Item No	Audit Team Comments		Audit Team Recommendations	Designer's Response
Checklist 2.1 – General				
2.1.1	Summary:	Risk of vehicle conflicts with pedestrians	1. It is recommended that the Designer reviews whether a sign warning vehicle drivers of the possible presence of pedestrians is required. 2. Approximately 100m to the east of the connection point, there is a footpath along the north side of Courtwick Lane commencing at Kingfisher Drive, and perhaps a link from the carriageway to the west end of that footpath could be provided to remove pedestrians from the carriageway at that point.	1. Agreed. A warning sign to diag. 544.1 has been indicated on the drawing, located adjacent to an existing perking deterrent bollard, immediately west of a passing space on the nearside carriageway. 2. Disagree. The suggested footpath link would need to be constructed over third party land and there would be third party land issues and potential long term maintenance problems if no one wished to take ownership.

Location:	<i>A (drawing 4485/314 B)- Courtwick Lane</i>		
	Description:	Courtwick Lane is narrow, and in places barely wide enough for a vehicle to pass a pedestrian walking in the ca

DMA Strider Max 4 Mobility Scooter	1.440m
Overall Length	0.650m
Overall Width	1.225m
Overall Body Height	0.165m
Min Body Ground Clearance	0.650m
Track Width	2.00s
Lock to lock time	1.650m
Wall to Wall Turning Radius

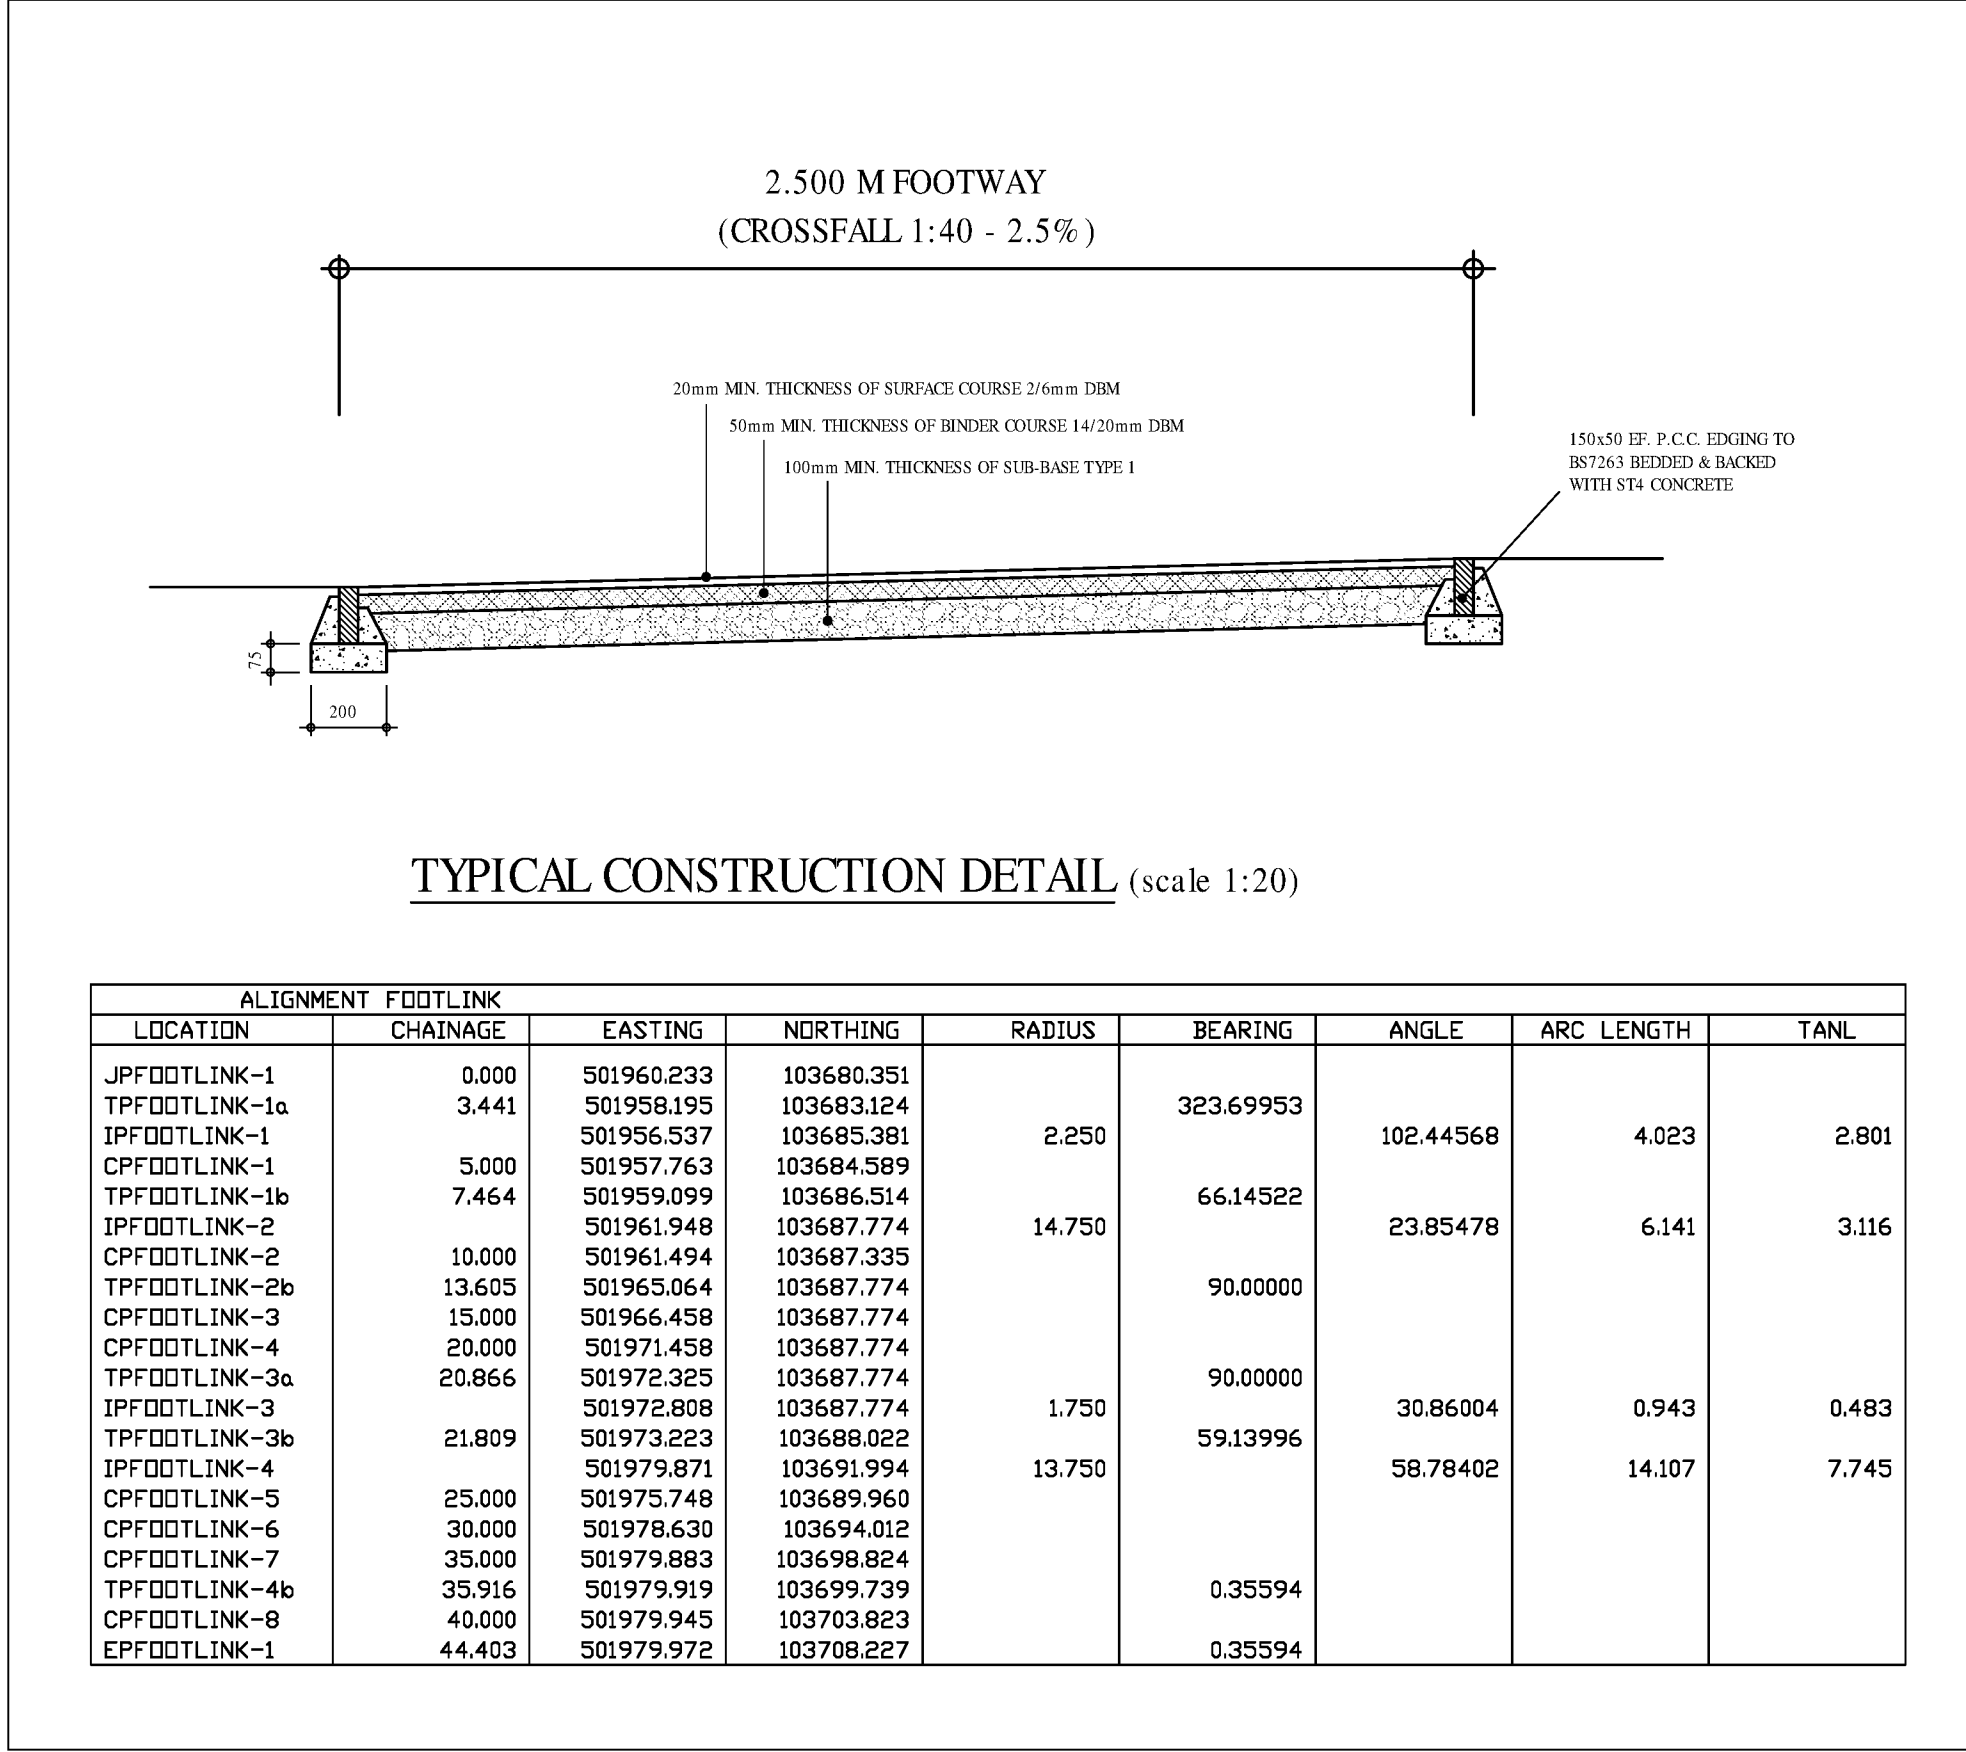
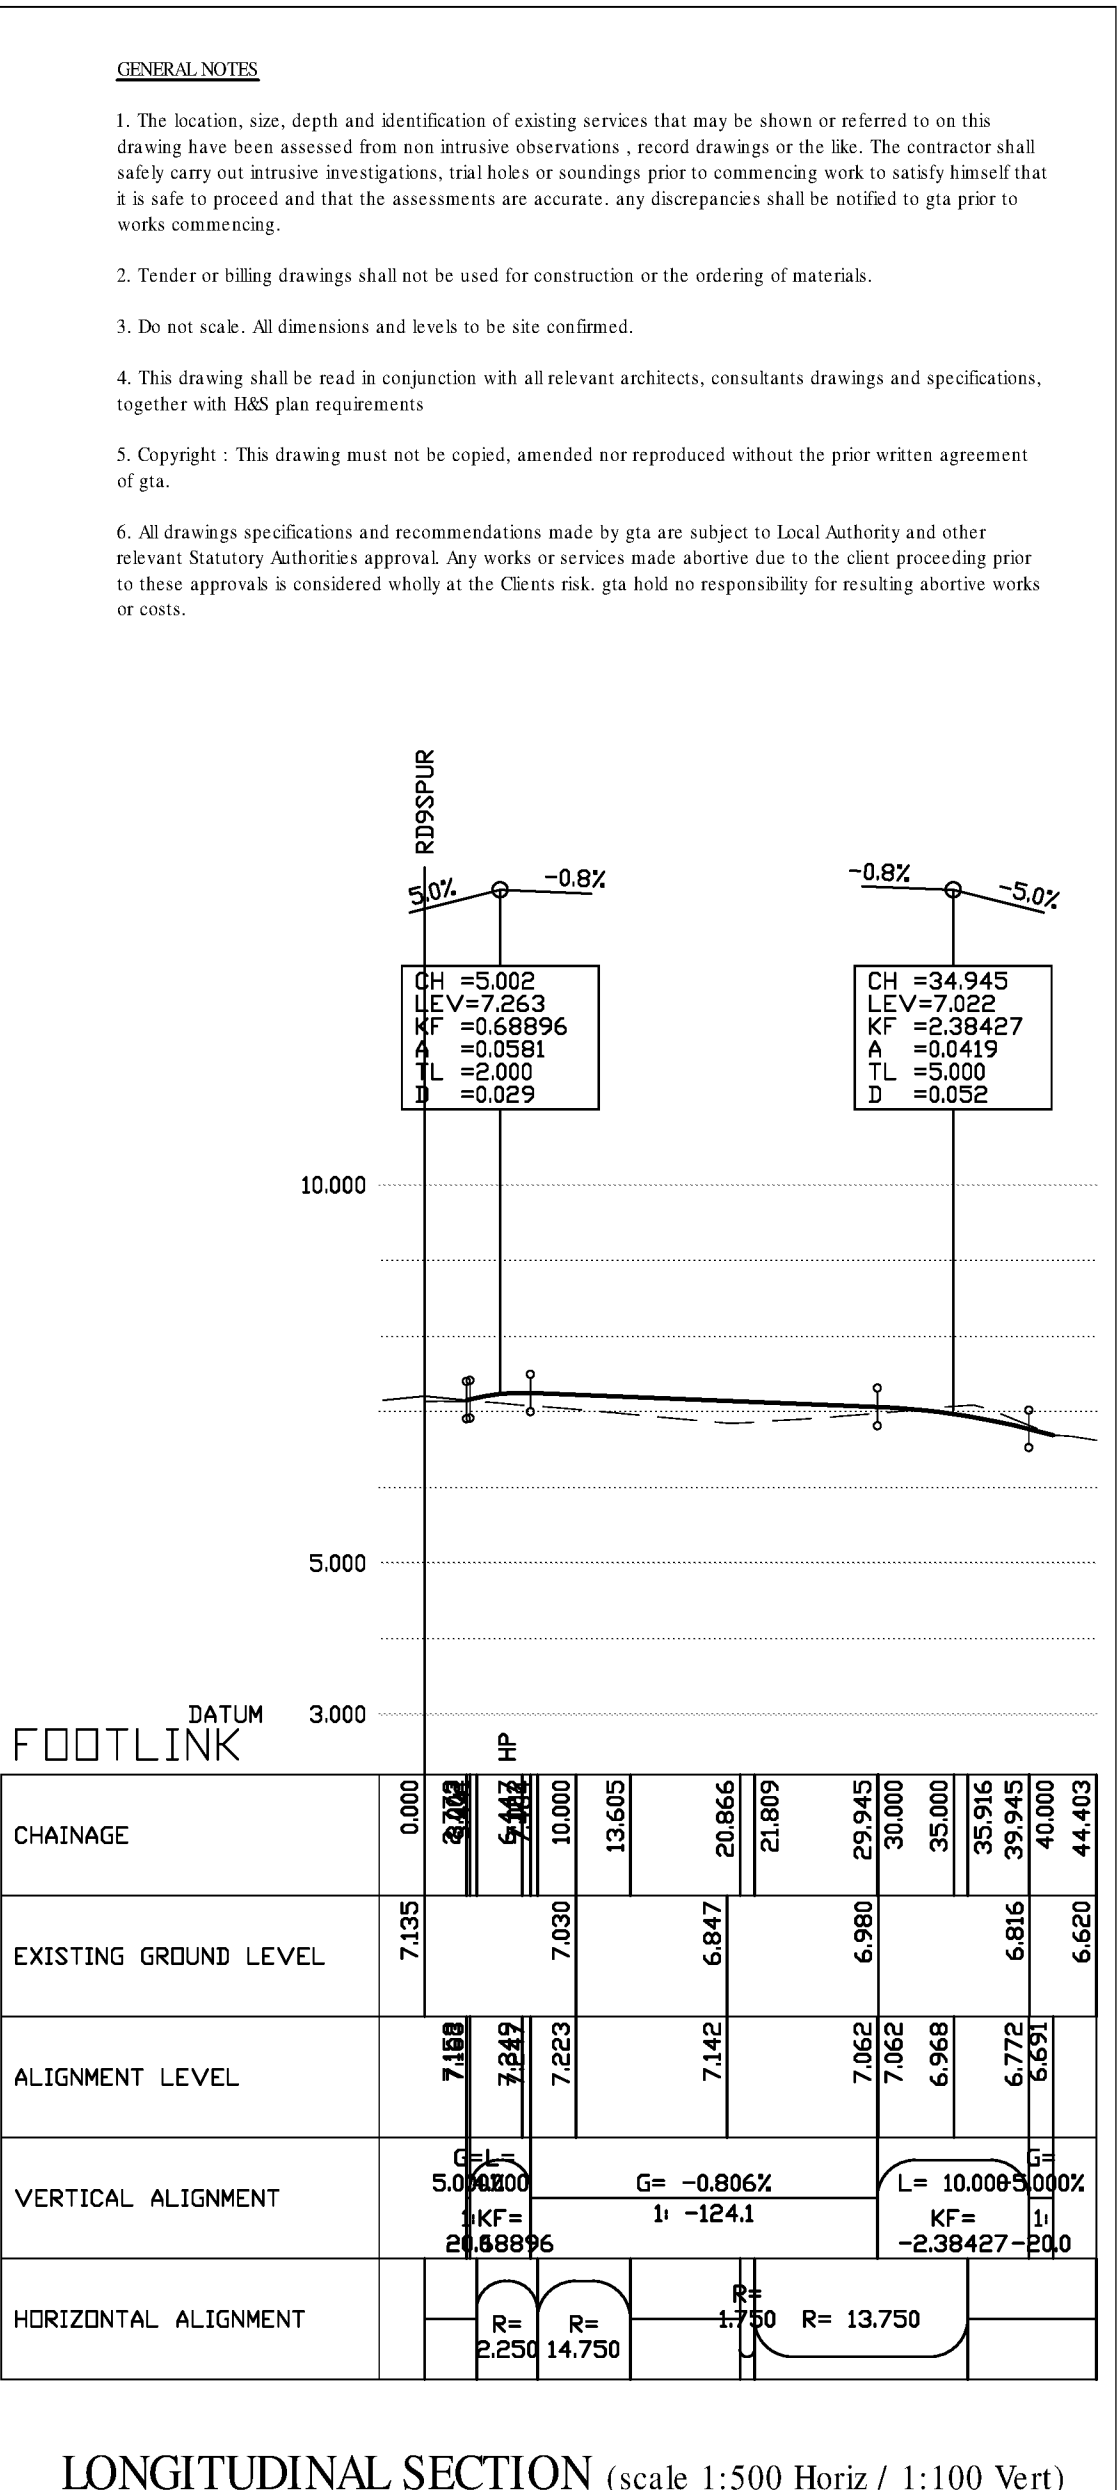
2.4.1	Summary:	Risk of trip on high kerb upstand	It is recommended that the paving is aligned across from one side to the other.	Agreed. Tactile paving has been realigned on the drawing.
	Location:	<i>B (drawing 4485/314 B)- Ernest Fitches Way</i>		
	Description:	The tactile paving shown at the side road junction does not align from one side to the other. This will result in upstand kerbing opposite, and possible risk of trip by a visually impaired pedestrian.
